3/2012/0874

From: David Hewitt
Sent: 21 November 2012 15:14
To: Graeme Thorpe
Subject: ST LEONARDS VICARAGE, BILLINGTON
Greame

I have given the application and the tree stuff some study, my comments are as follows:

DRAWING TITLE:
Proposed Site Plan

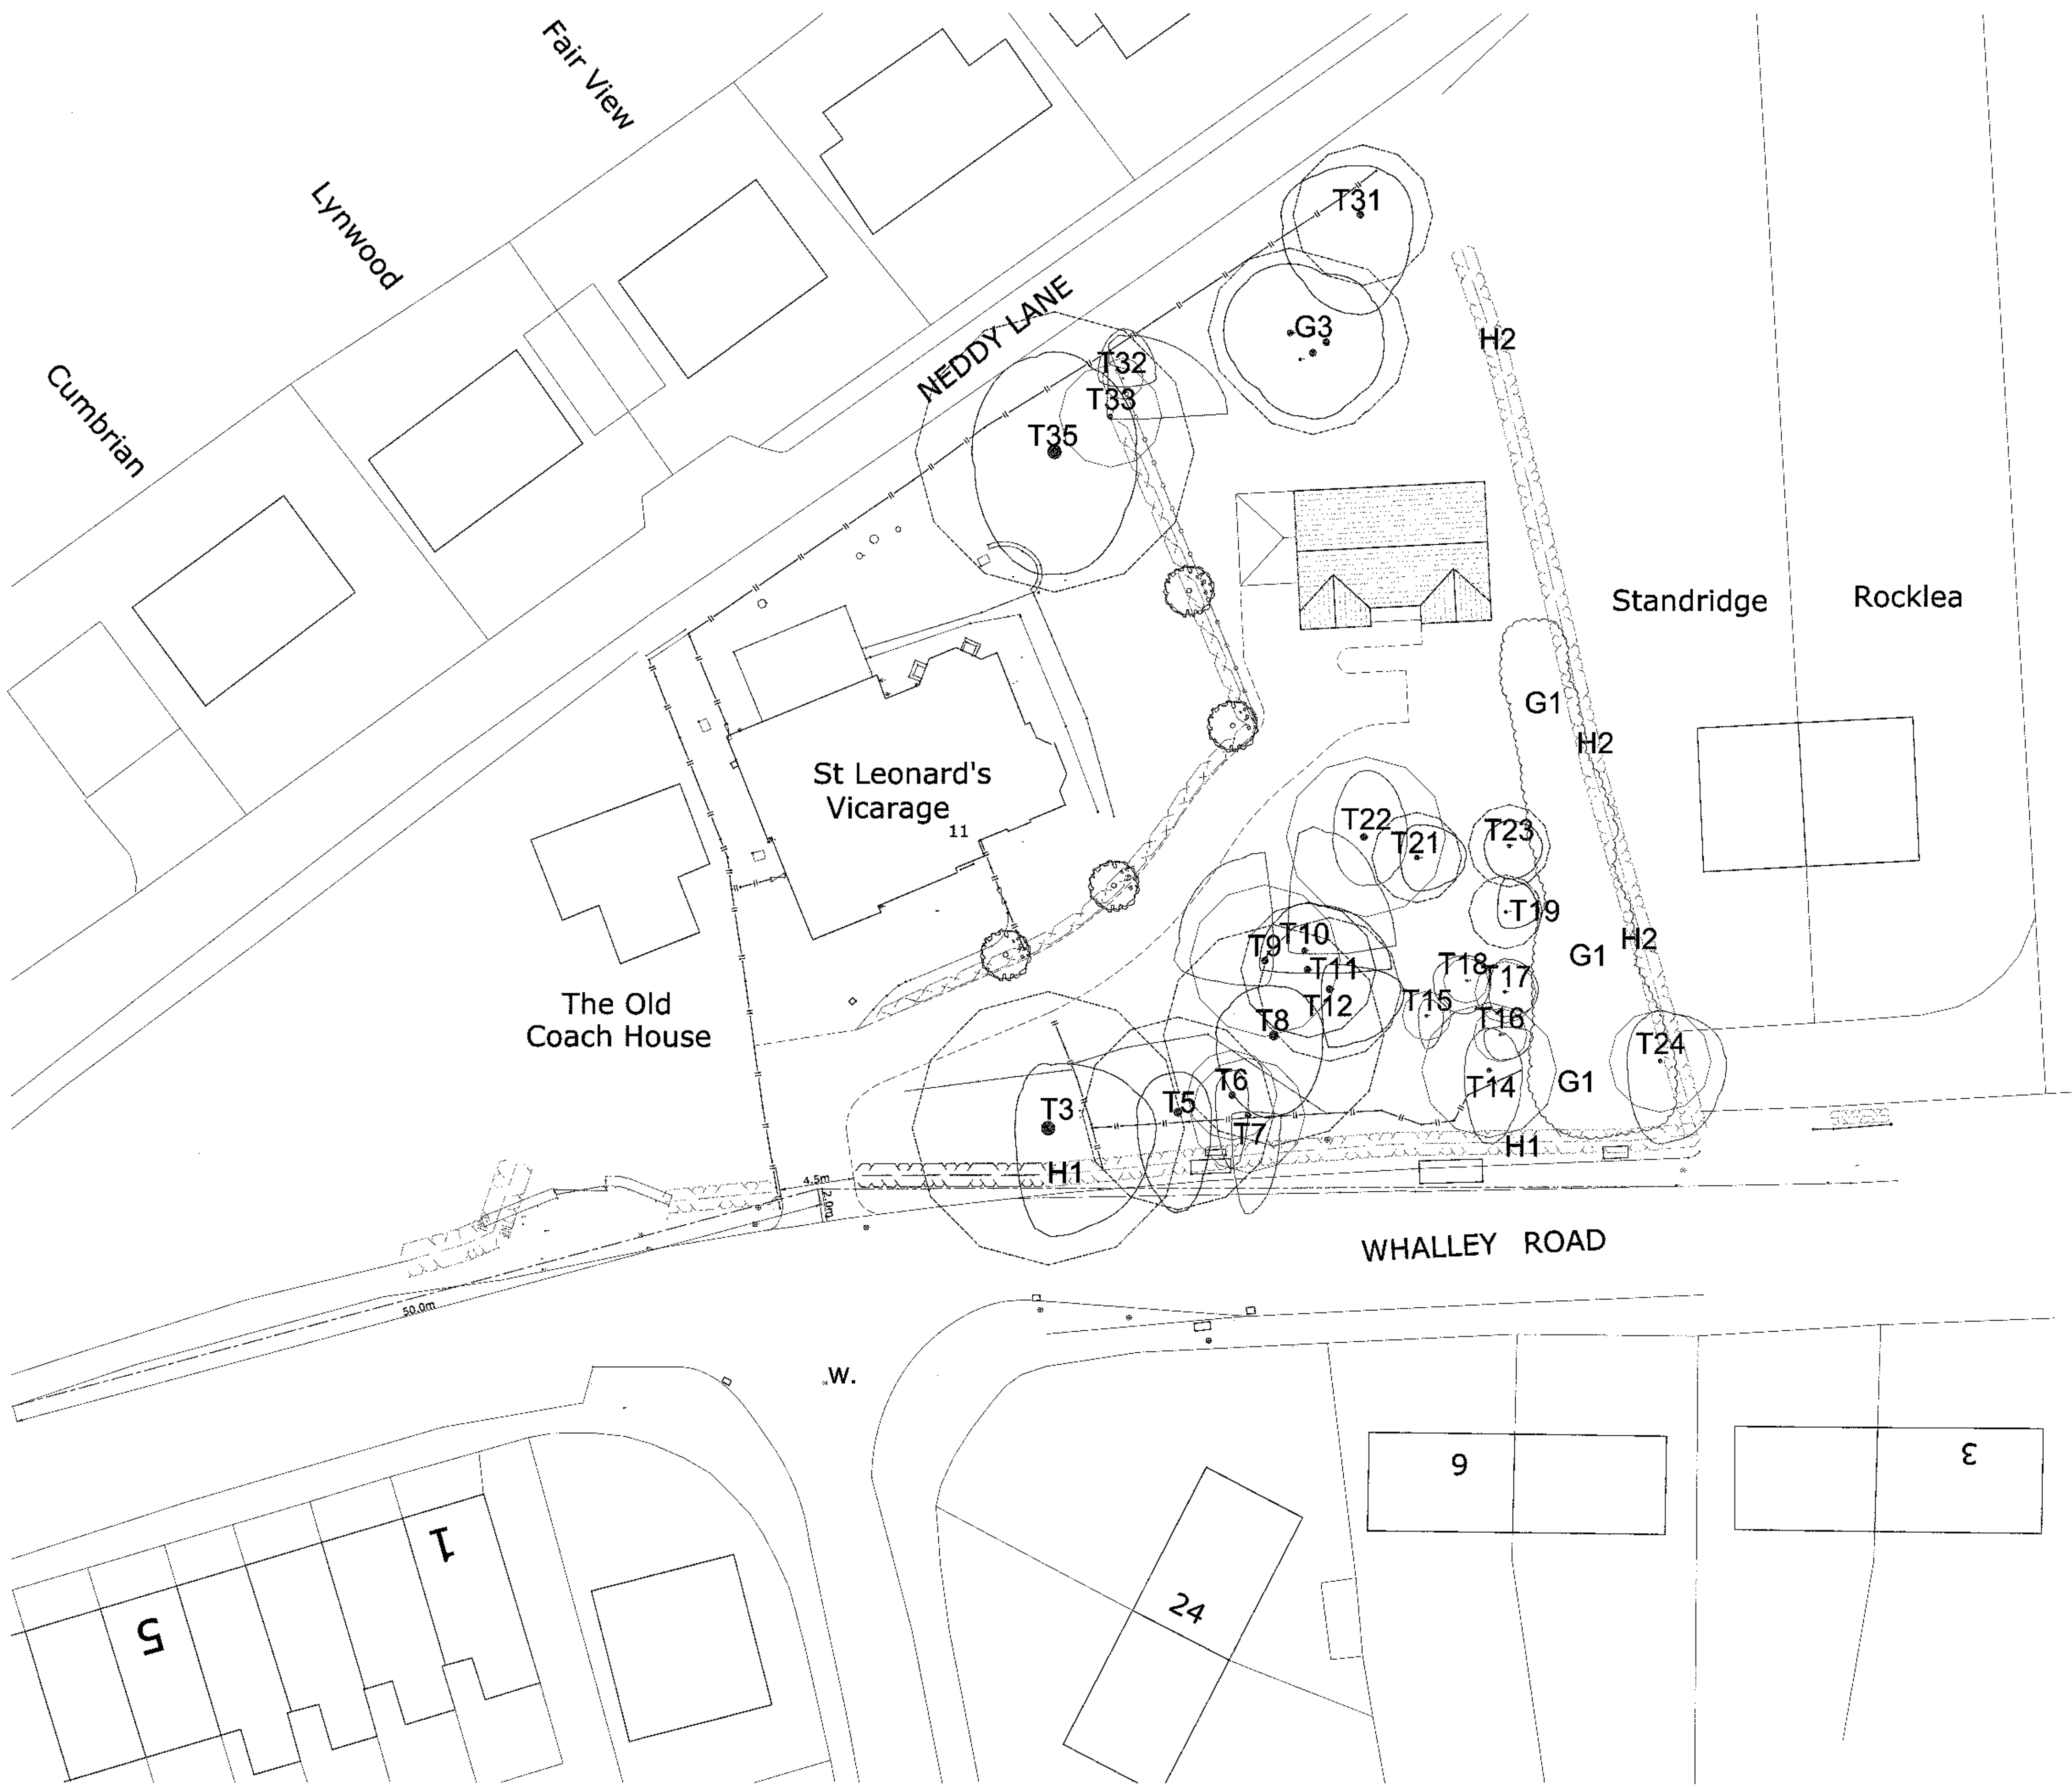
- 35 trees identified only 10 retained + 1 group - resulting in a 70% loss of tree cover
- only 4 of the 25 trees to be removed are recommended for removal due to poor condition and/or limited life
- majority of trees indicated for removal are are C1 category trees - these are trees of low quality but sufficient condition to retain for minimum of 10 years until new planting is established

Its another example of what may be considered to be the collective visual amenity value/neighbours amenity of trees against a considerable reduction in tree cover
